**KIRKLEES METROPOLITAN COUNCIL
INVESTMENT & REGENERATION SERVICE**

**DELEGATED DECISION FOR APPLICATION FOR CERTIFICATE OF
LAWFUL DEVELOPMENT**

Reference no.: 2026/CL/91893/E

Site: 4, Manor Grange, Shepley, Huddersfield, HD8
8AH

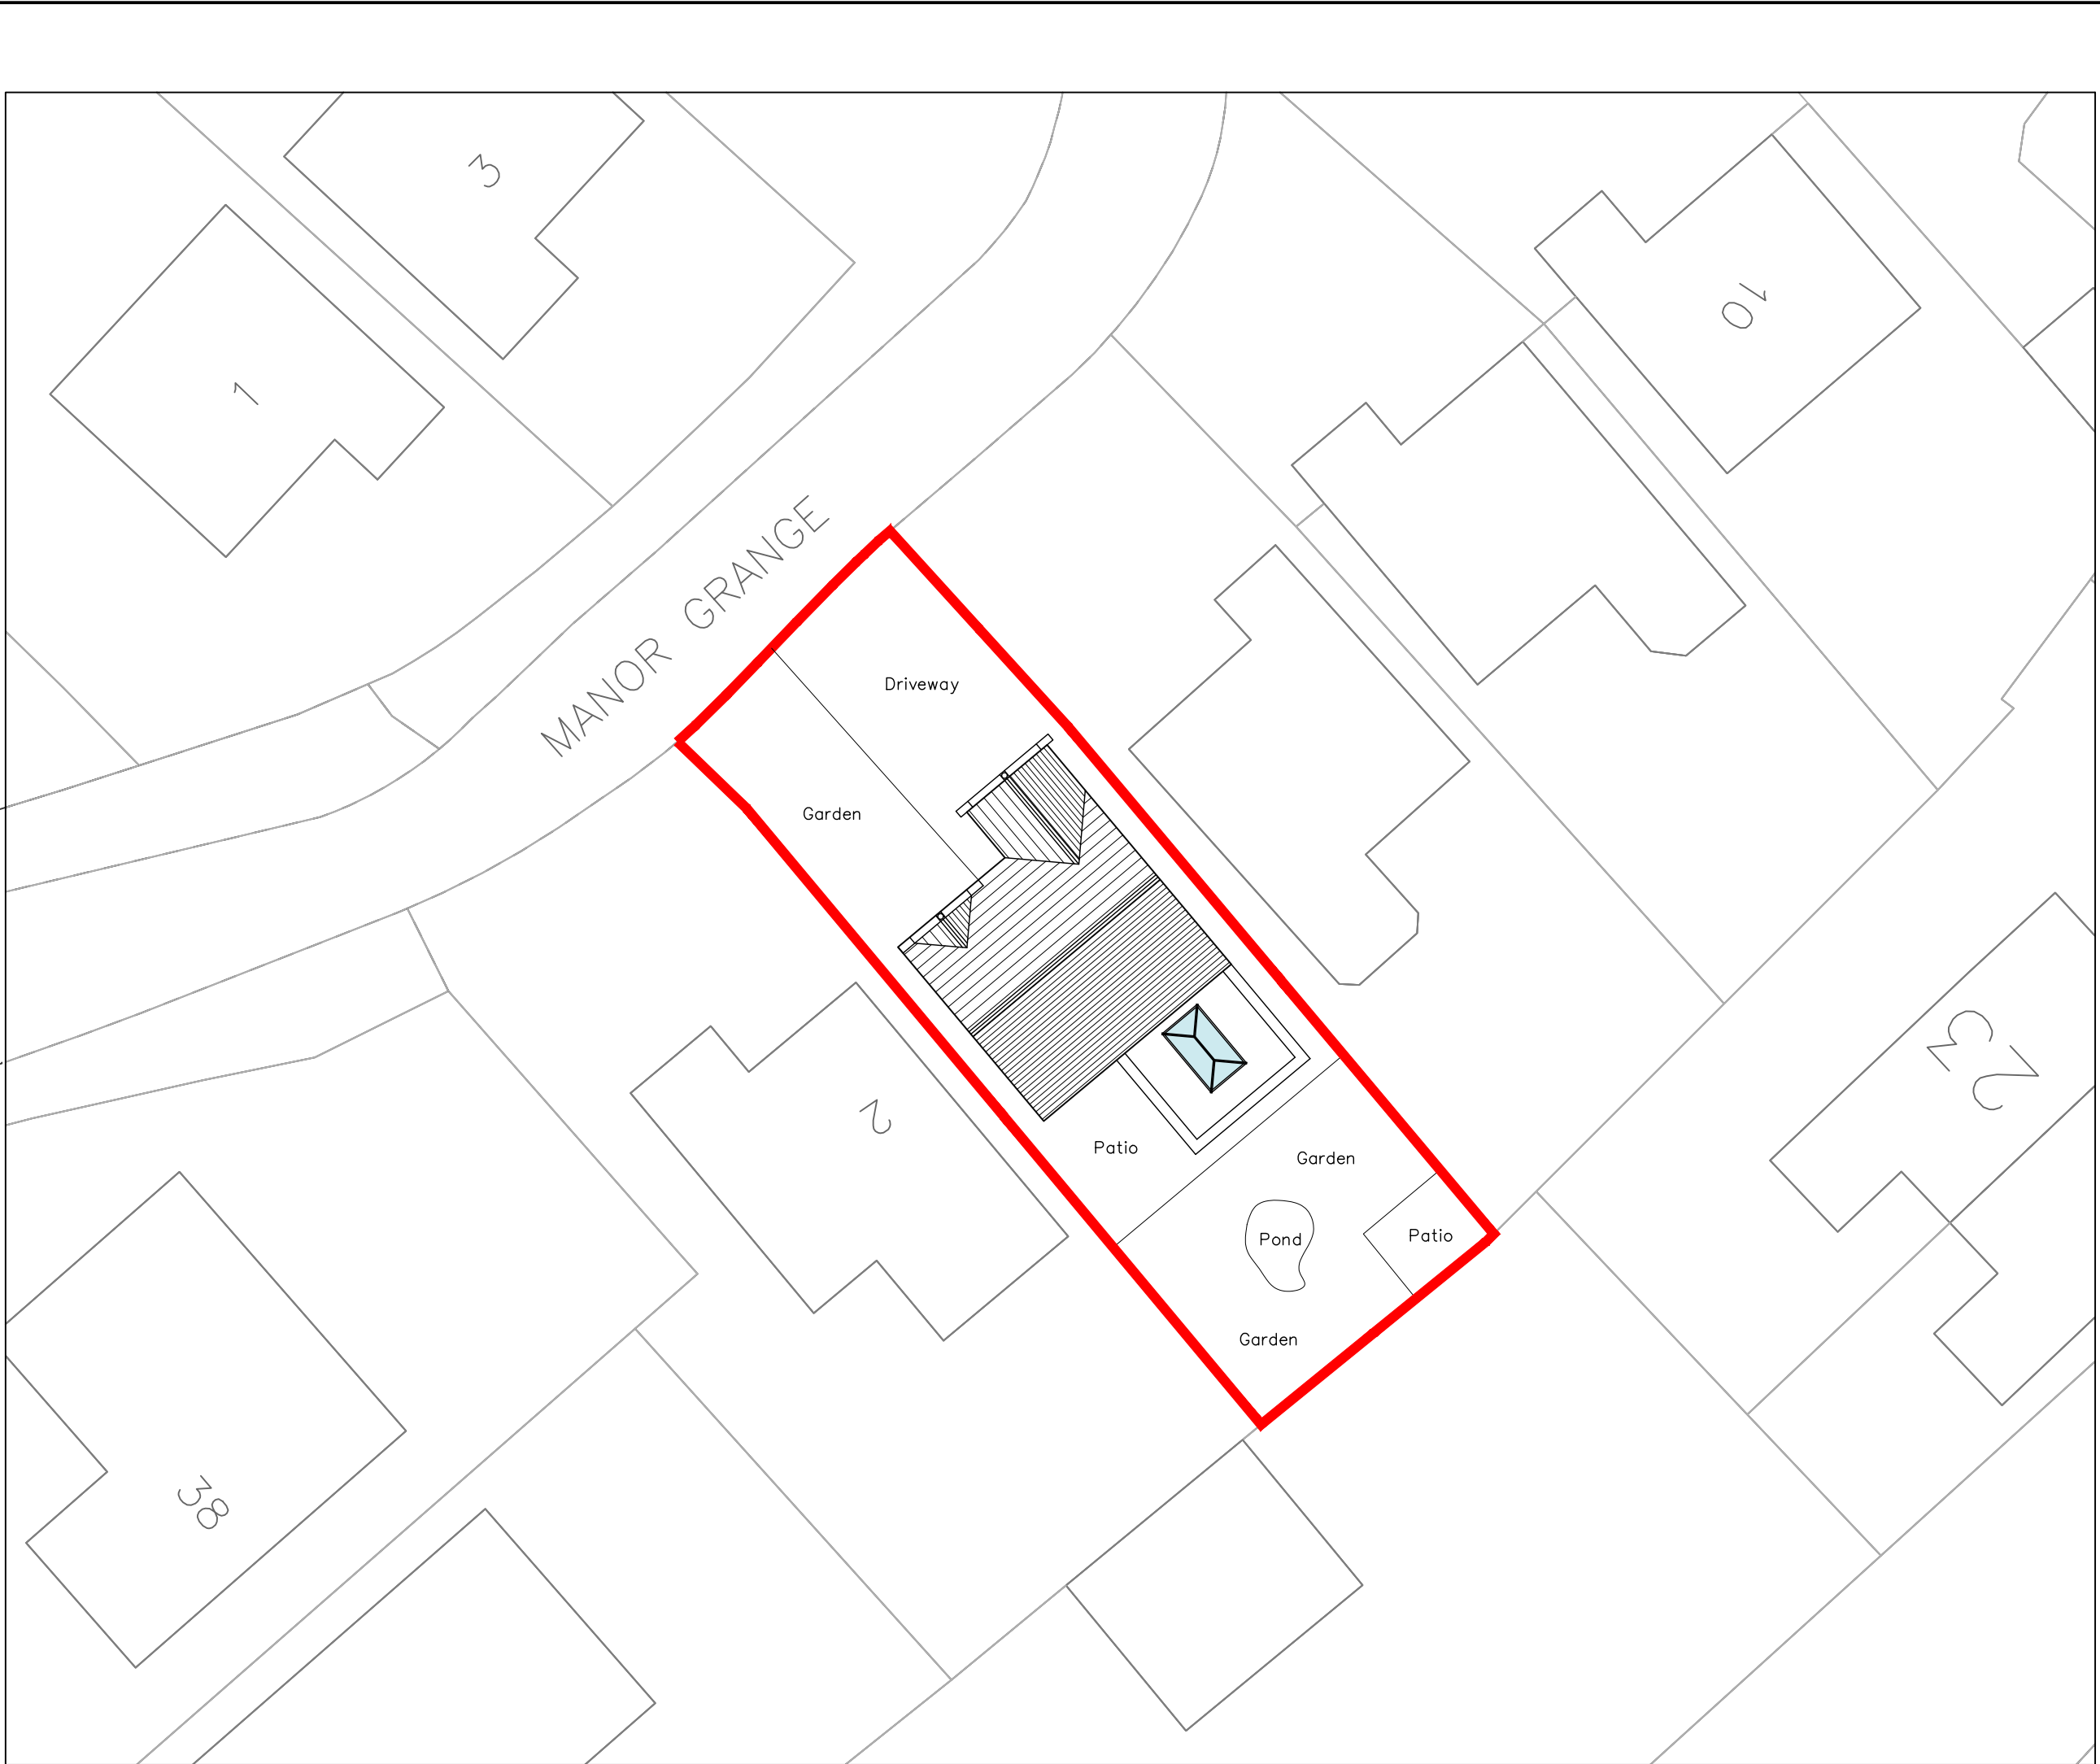
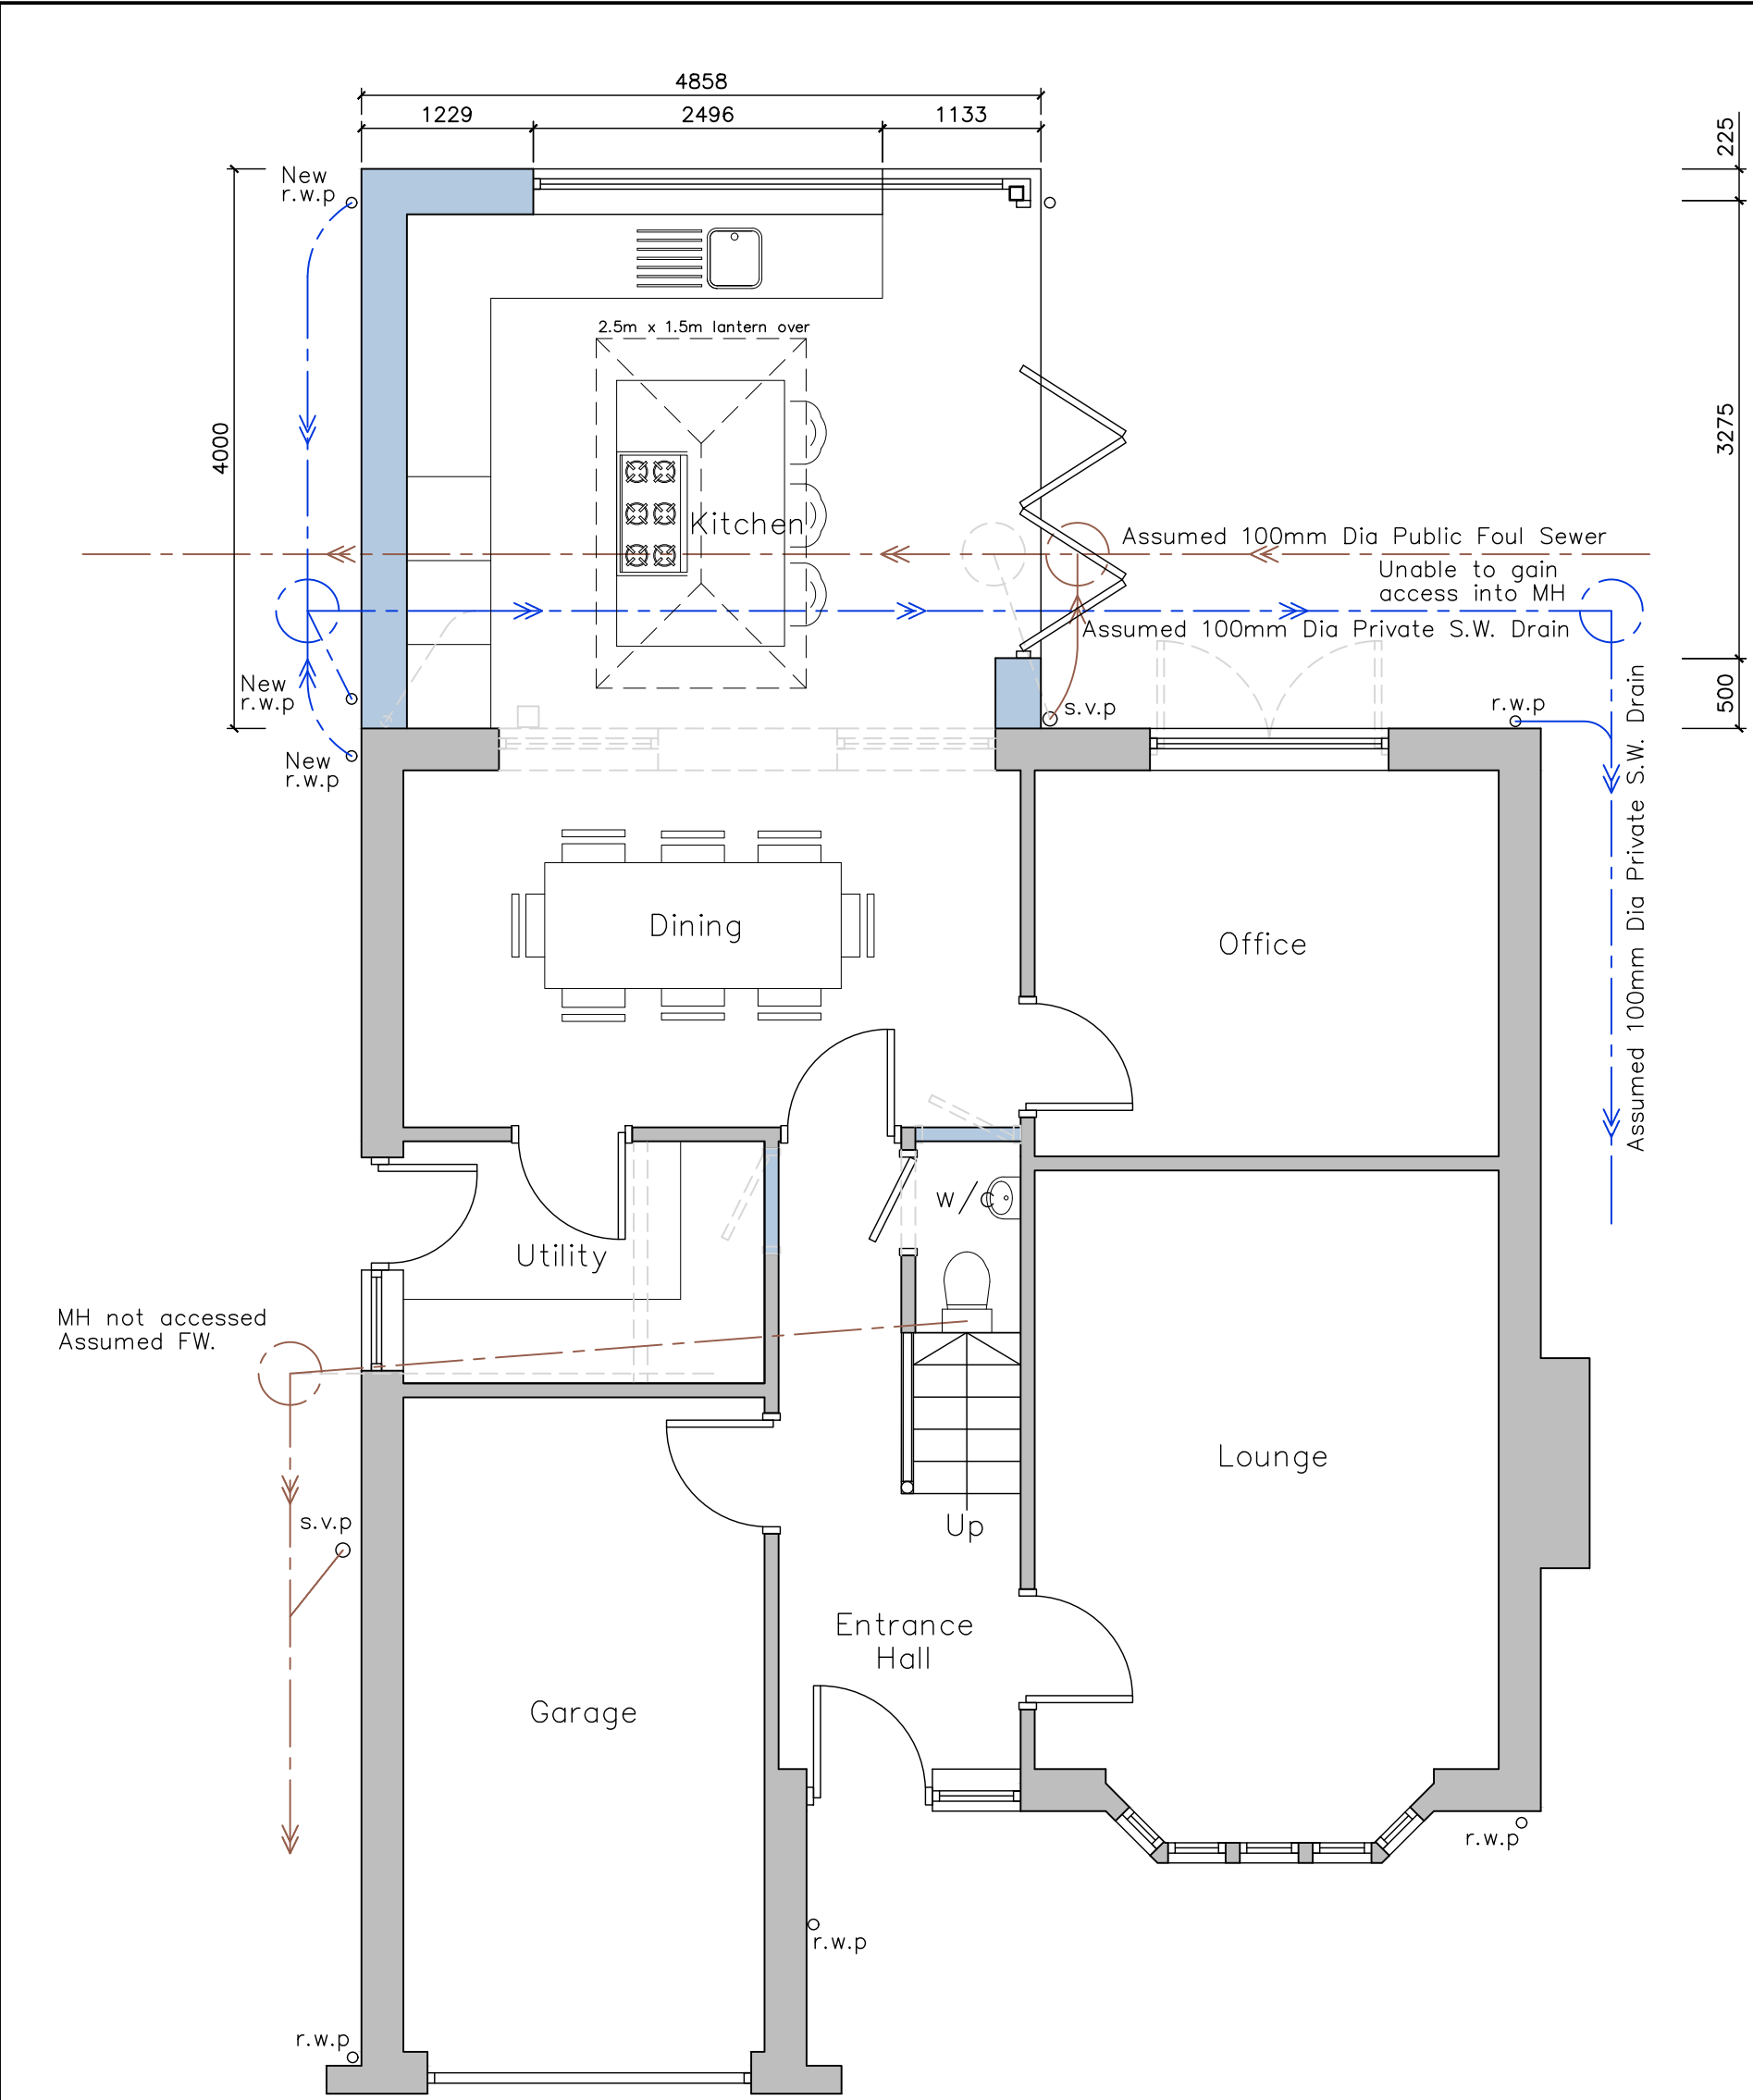
The proposed extension would lie flush with the side elevation facing No. 6 and would project 4 metres with a width of 4.8 metres. The height of the extension would be 3 metres to the top of the parapet with the construction materials being natural coursed stone.

Comment: *The enlarged part of the dwellinghouse would have a single storey and would not extend beyond the rear wall of the original dwellinghouse by more than 4 metres and it does not exceed 4 metres in height.*

Comment: *The enlarged part of the dwellinghouse would be within 2 metres of the boundary of the curtilage of the dwellinghouse however does not exceed 3 metres in height to the eaves.*

Comment: *Not applicable as the enlarged part of the dwellinghouse would not extend beyond a wall forming a side elevation of the original dwellinghouse.*

The single storey rear extension benefits from a general planning permission granted by virtue of Article 3(1) and Schedule 2, Part 1, Class A of the Town and Country Planning (General Permitted Development) (England) Order 2015 (as amended) subject to conditions within Class A.3 of the same Order.
